Application No: EP/126/20/HH
Site Address: 56 Angmering Lane East Preston BN16 2TA
Description of works: Resubmission (EP/37/20/HH) of proposed extensive refurbishment of existing 2-storey dwelling to include, single storey side/rear extensions, 2-storey rear extension, roof extension and front double garage

Re: EP/126/20/HH 56, Angmering Lane, East Preston BN16 2TA

PROPOSED EAST ELEVATION 1:50

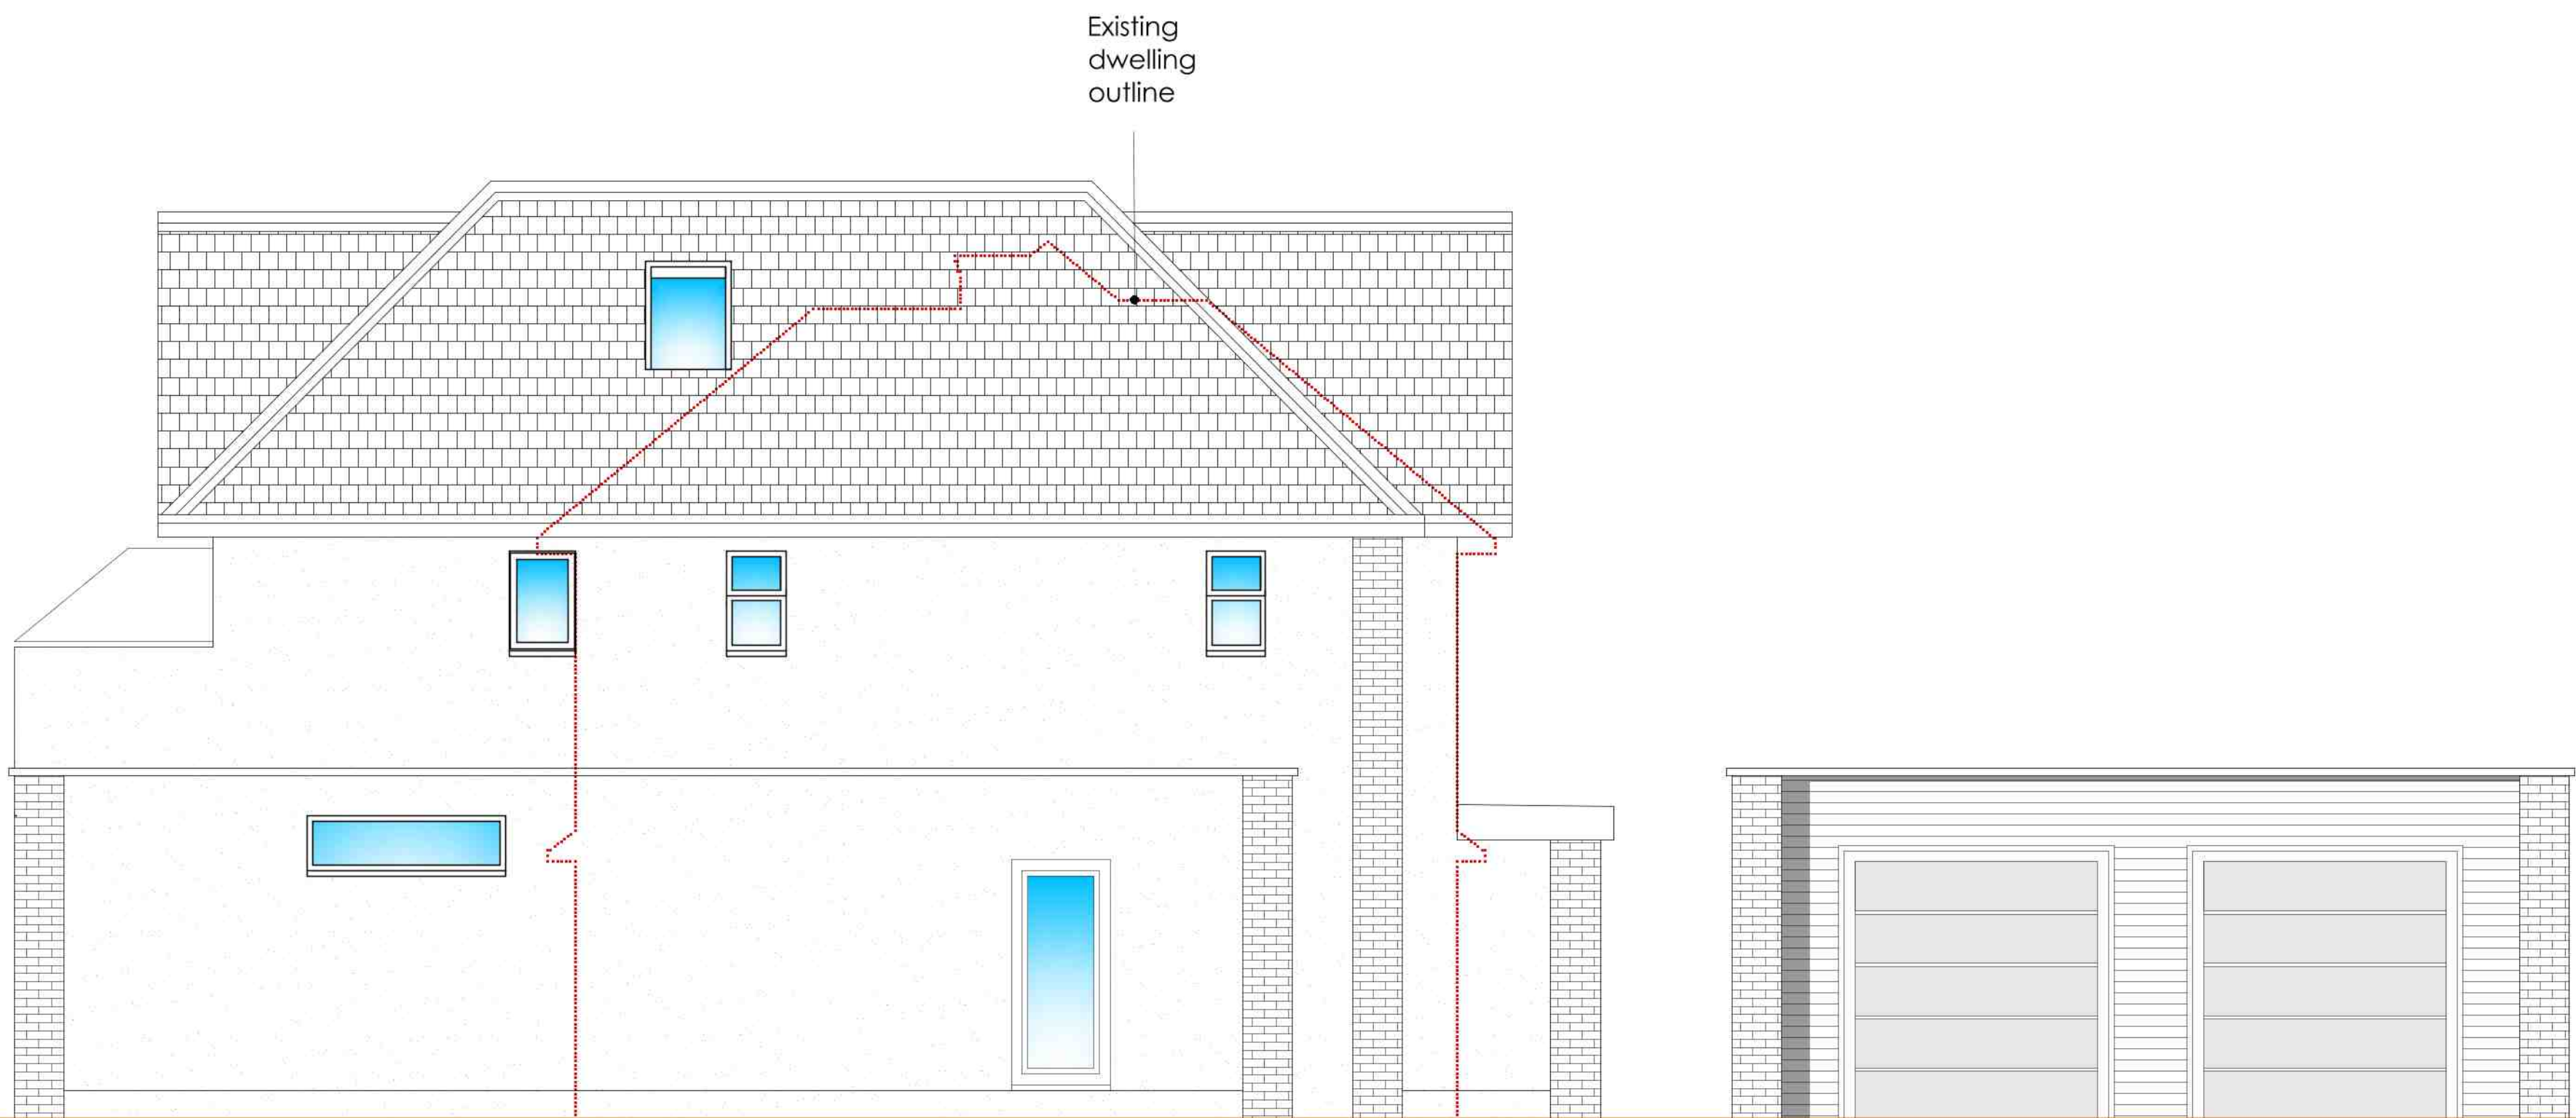
The proposed development shows a new garage located at the front of the property. This garage featured on the previous plans for number 56 for which planning permission was refused. The situation regarding the

garage has not changed. The garage would project beyond the building line and properties on the Willowhayne have covenants that restrict anything being built in front of the building line. Number 56 is no exception and has such a covenant in place. If the garage was to be built at its planned location it would be in breach of this covenant and therefore unlawful. I assume planning permission was previously refused because Arun District Council did not want to approve something that was unlawful.

The cedar cladding planned for the garage is also inappropriate and completely out of character. The East Preston Neighbourhood Plan states: -

Development Principles (Page 21) 4.12: - The materials used in new or altered buildings should harmonize in both colour and texture with the materials used in adjoining buildings.

Cedar cladding on the sides of the garage does not satisfy these criteria.

PROPOSED WEST ELEVATION 1:100

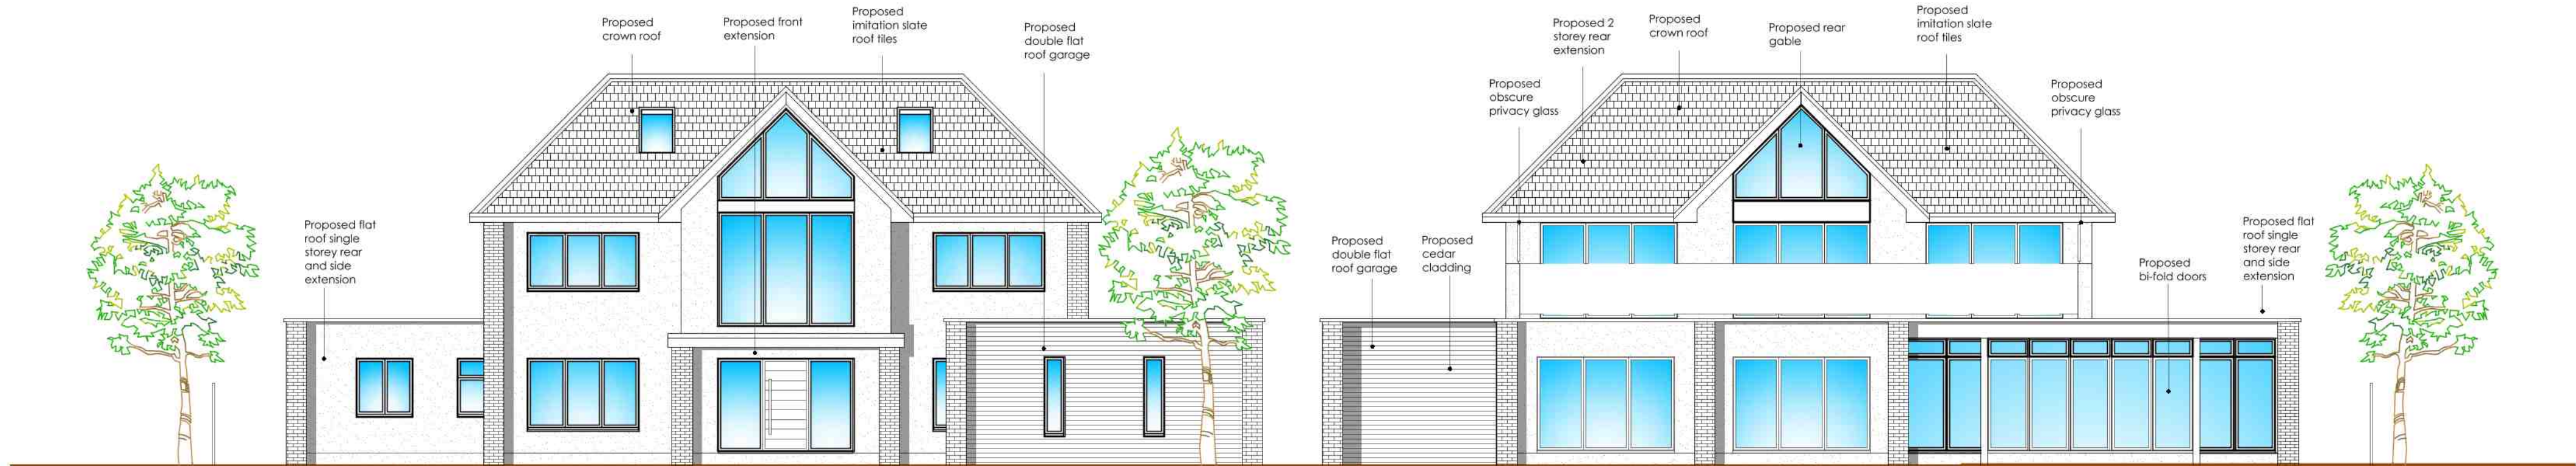
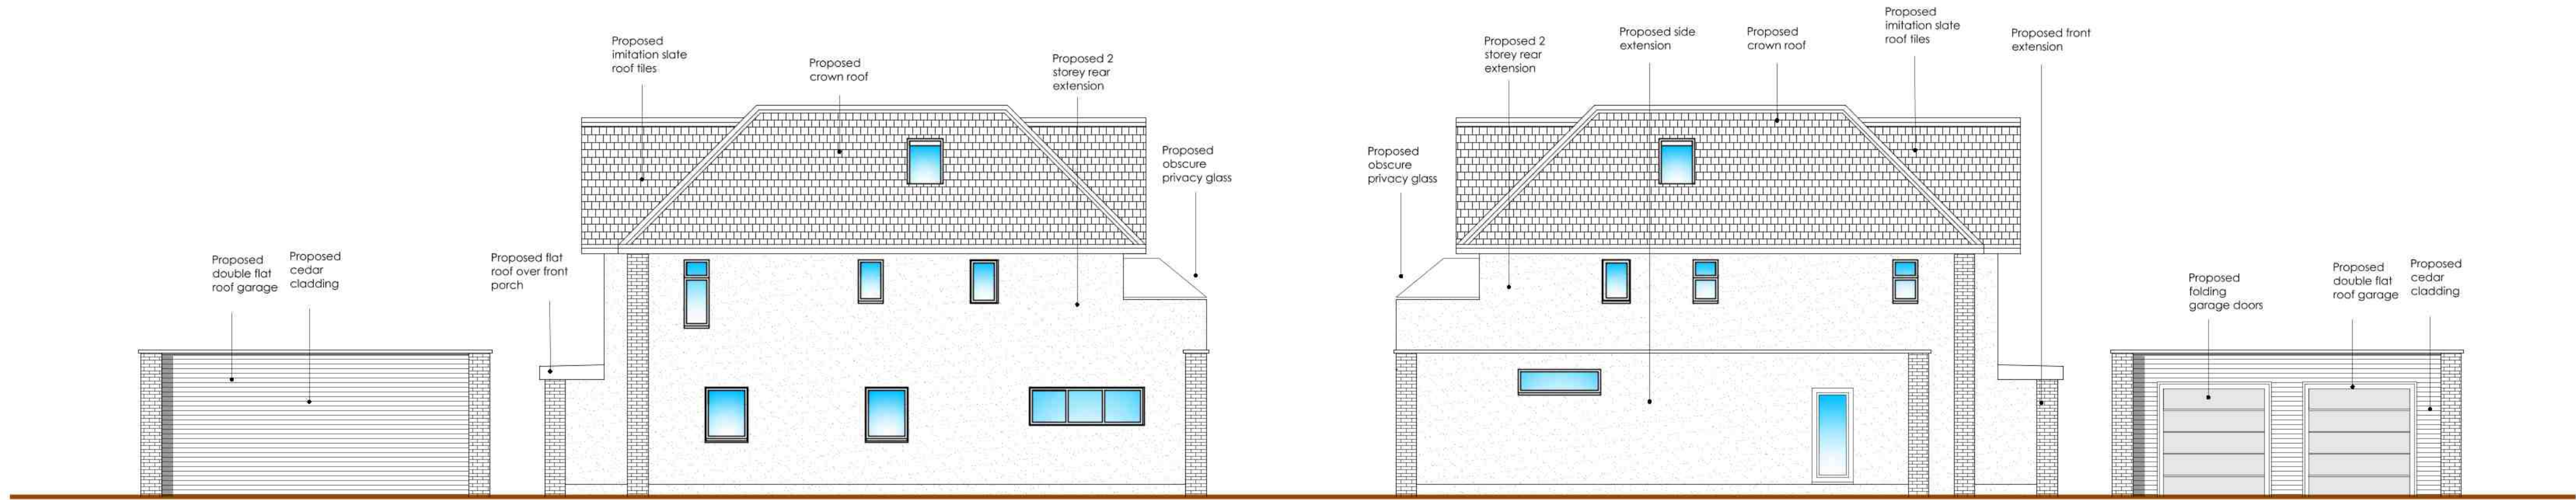
I live directly opposite to No. 56. The addition of a third storey with large windows will result in the development being high and an invasion of my privacy. The large windows on the second and third floors will be very prominent and will appear intrusive. No other properties in Angmering Lane have a third storey. The East Preston Neighbourhood Plan states: -

Development Principles (Page 21) 4.14: - New or altered building that exceed two storeys in height will rarely be acceptable.

The planned development is so large, it will dominate the surrounding properties and will be detrimental to the street scene. The East Preston Neighbourhood Plan states: -

Development Principles (Page 21) 4.10: - It is important to avoid new building which appear overbearing by reason of their size and alterations which harm the character of a road.
